From: roger harden [REDACTED]
Sent: 27 July 2011 10:02
To: Anita Gardner
Subject: RE: Wandleys Farm, Walberton WA/32/11/DOC

I have received your revised landscape plan today. Please can you confirm the pot sizes/height of the proposed plants.

SITE PLAN 1:100

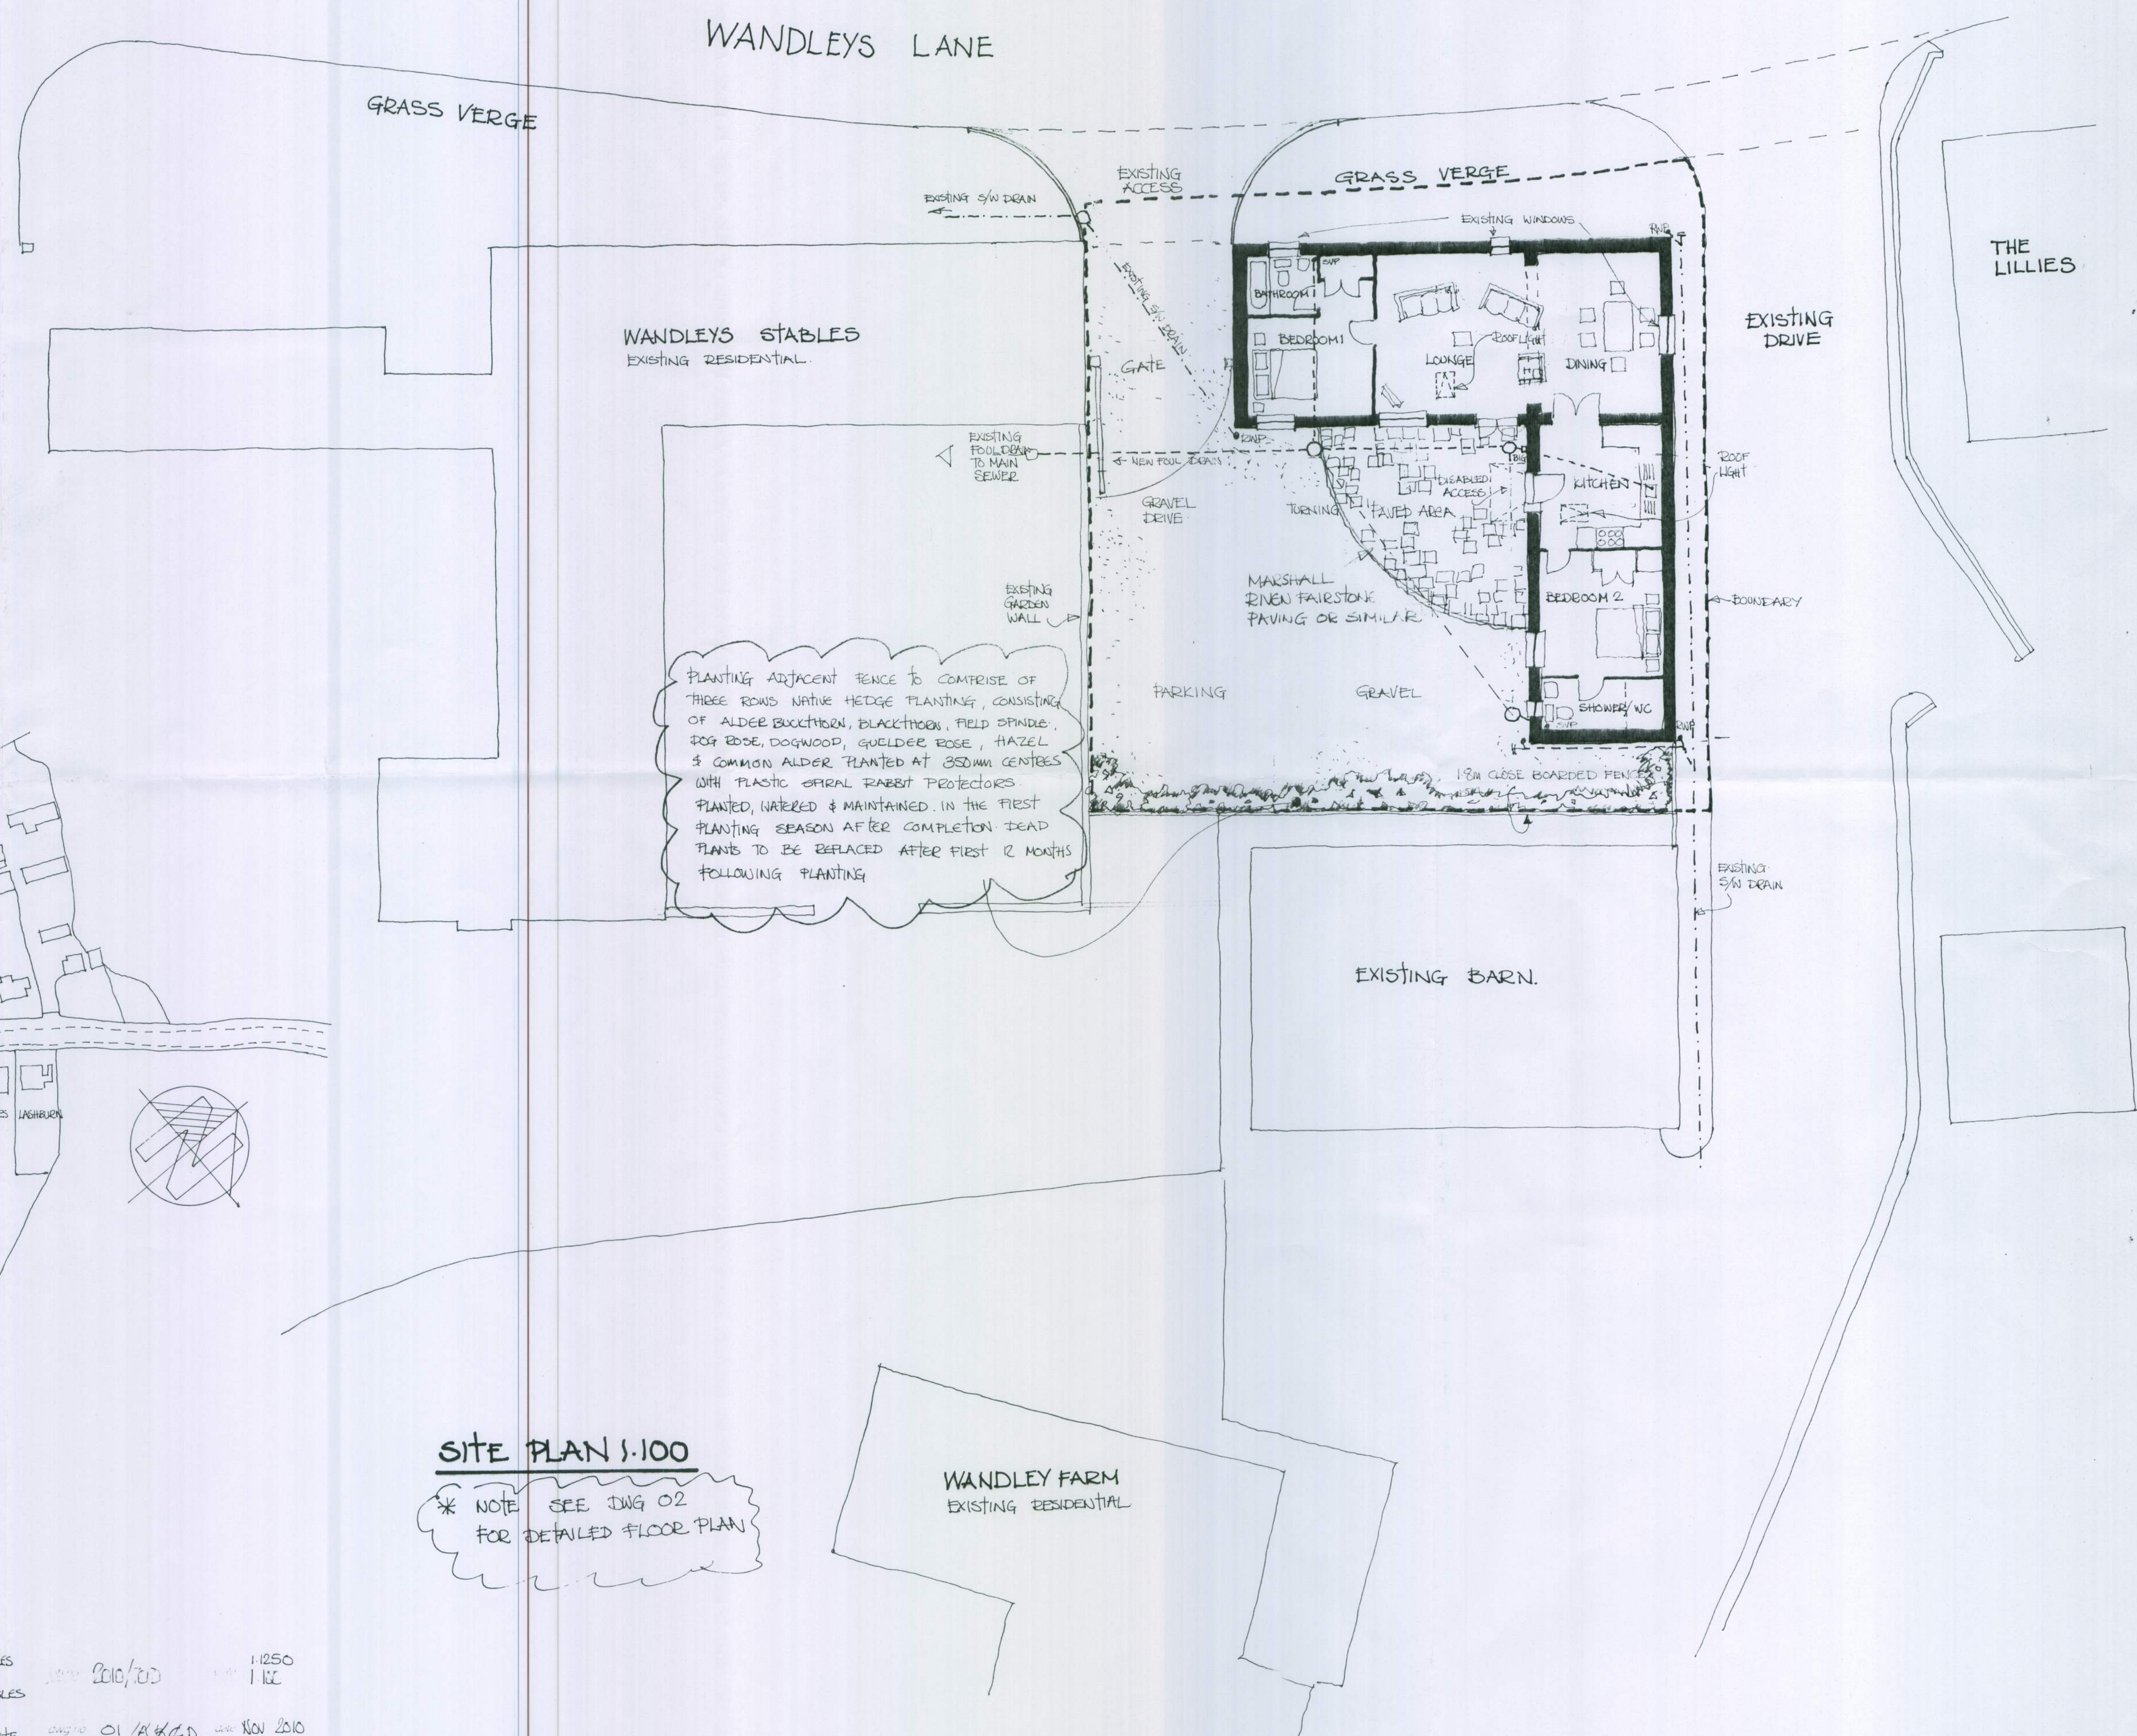
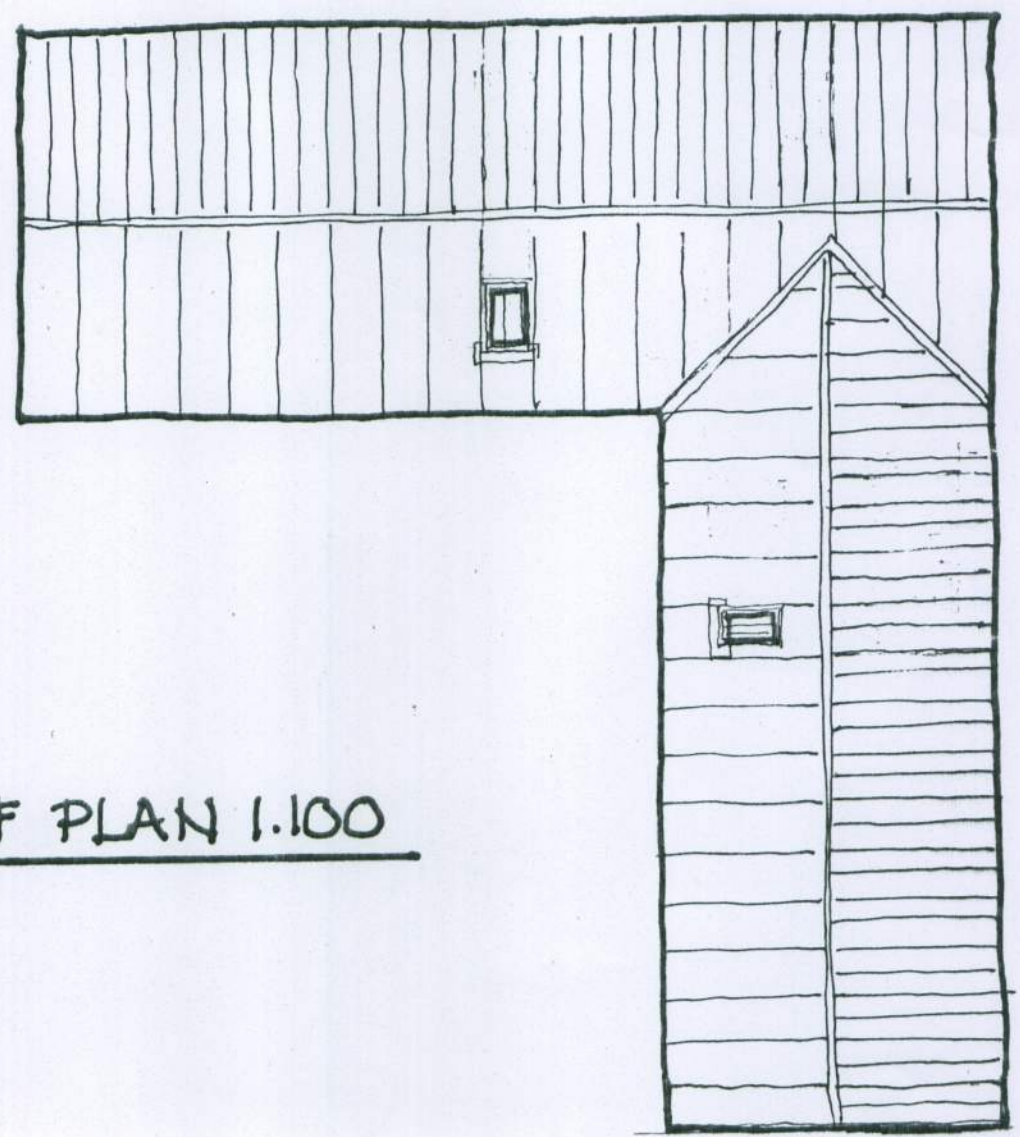
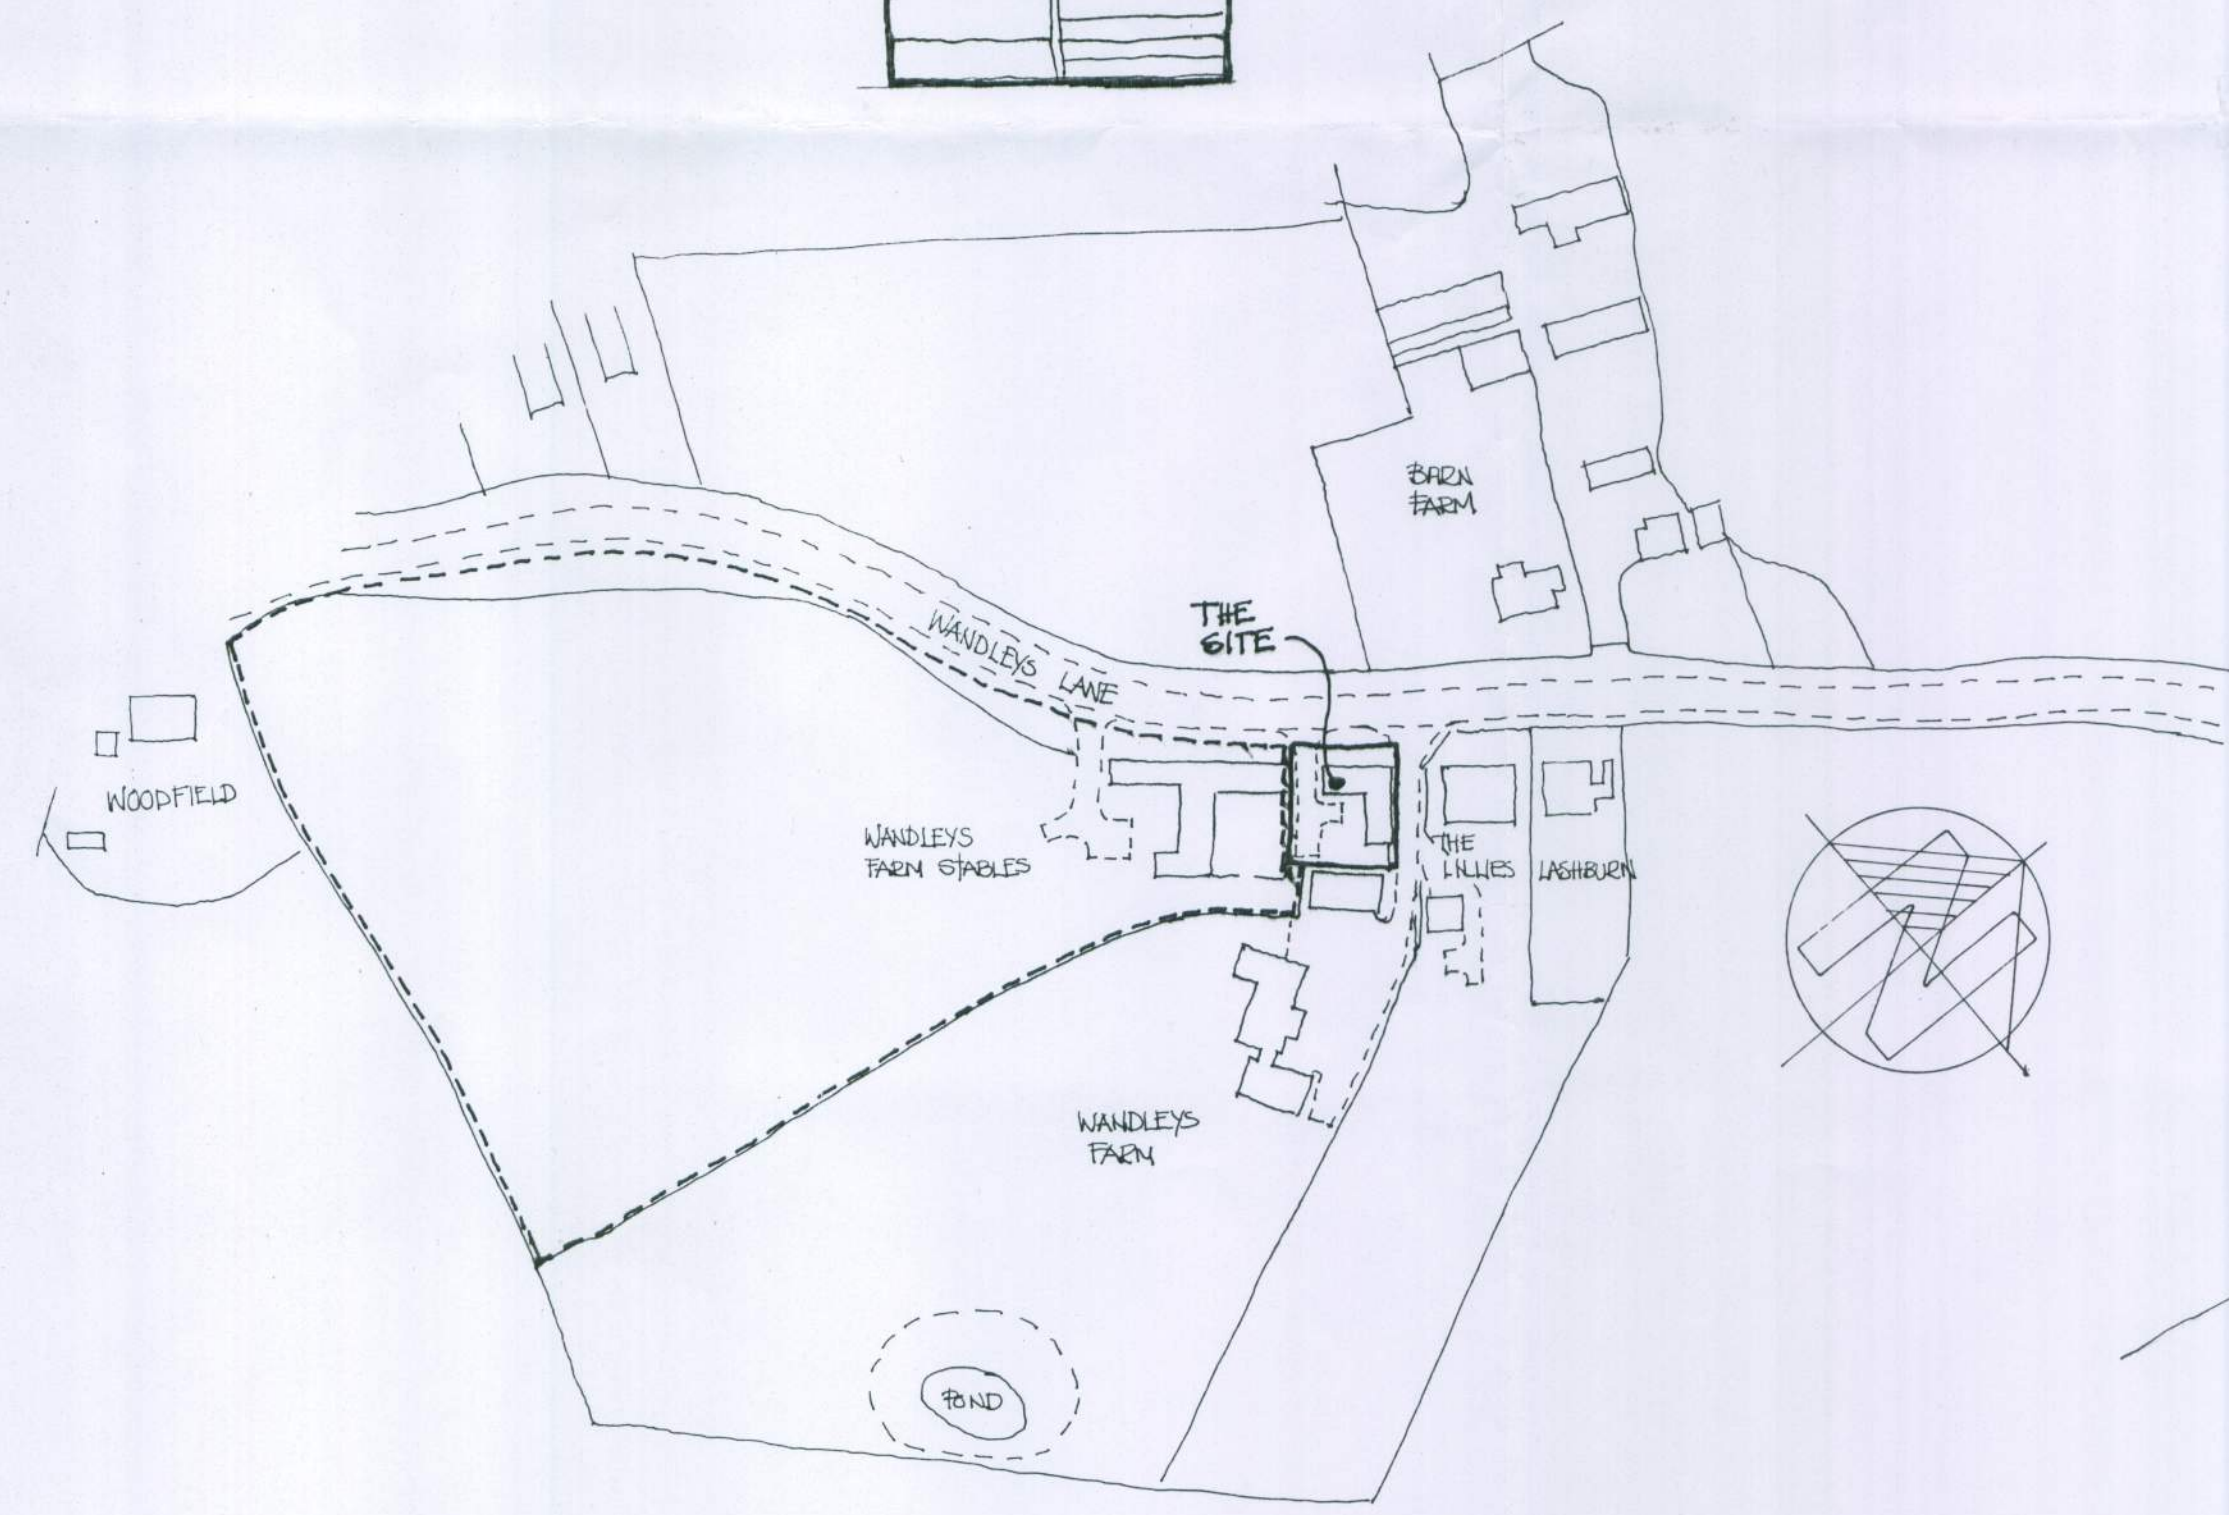
Dear Roger,
Can I assume your client proposes to use bare rooted plants of these sizes.
Regards
Anita

Roger,
Thankyou for your prompt response. I don't need to know the anticipated plant heights. I need confirmation of the sizes when planted in order to ensure that they will fill the space adequately and stand a chance of establishing relatively quickly.
Thanks
Anita

We have discussed this and as far as I know this is to be the case.

To stand the best chance of survival, the best plants are of the "bare-rooted" type about 450 - 600mm in height planted at about 350mm centres and will grow 300-400mm per annum subject to weather and soil conditions. Annual pruning at the top of up to 100mm - 150mm will produce a more dense growth at a lower levels and improve the general visual aspect of the mature hedge.

Dog Rose, Dogwood, Guelder Rose, up to 750mm

Field Spindle, Blackthorn, Buckthorn, up to 2m in height

Alder & Hazel up to 3m in height
